Permit Number: 050488

This is to certify that Dodge Sarah M & /Home own
has permission to Add a 24x10 deck
AT 89 Brook Rd

Permit No: 05-0488	Issue Date: MAY 23 2005	CPL: 376 C010001
-----------------------	-----------------------------------	---------------------

Dept: Building **Status:** Approved with Conditions **Reviewer:** Tammy Munson **Approval Date:** 05/17/2005

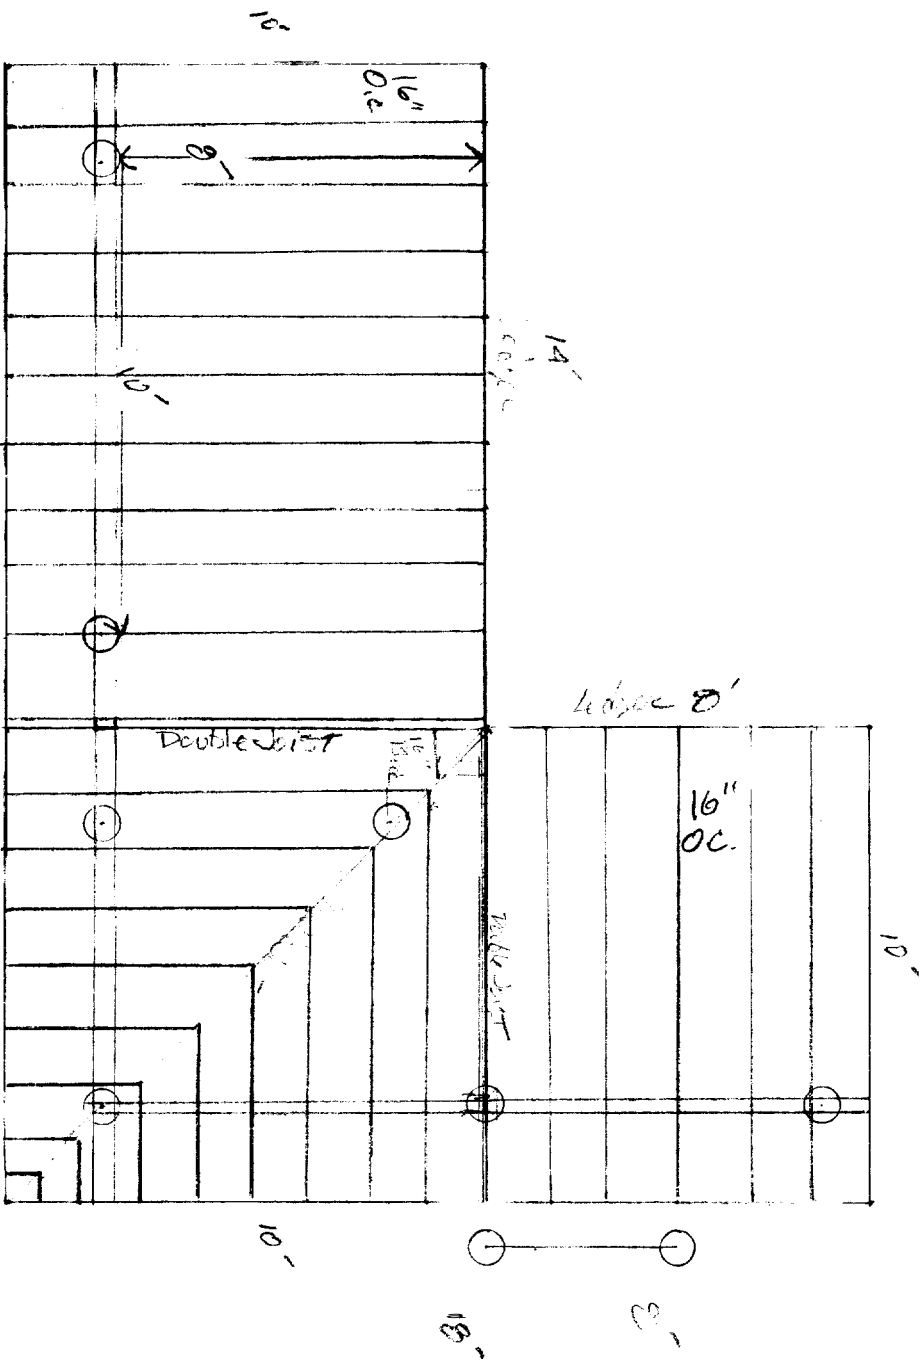
5/11/05-tmm: left message w/owner - need double girder, balluster spacing, ledger attachment info

- 1) Permit approved based on the plans submitted and reviewed w/owner/contractor, with additional information as agreed on and as noted on plans.

5/17/05-tmm: spoke w/owner - ok to issue
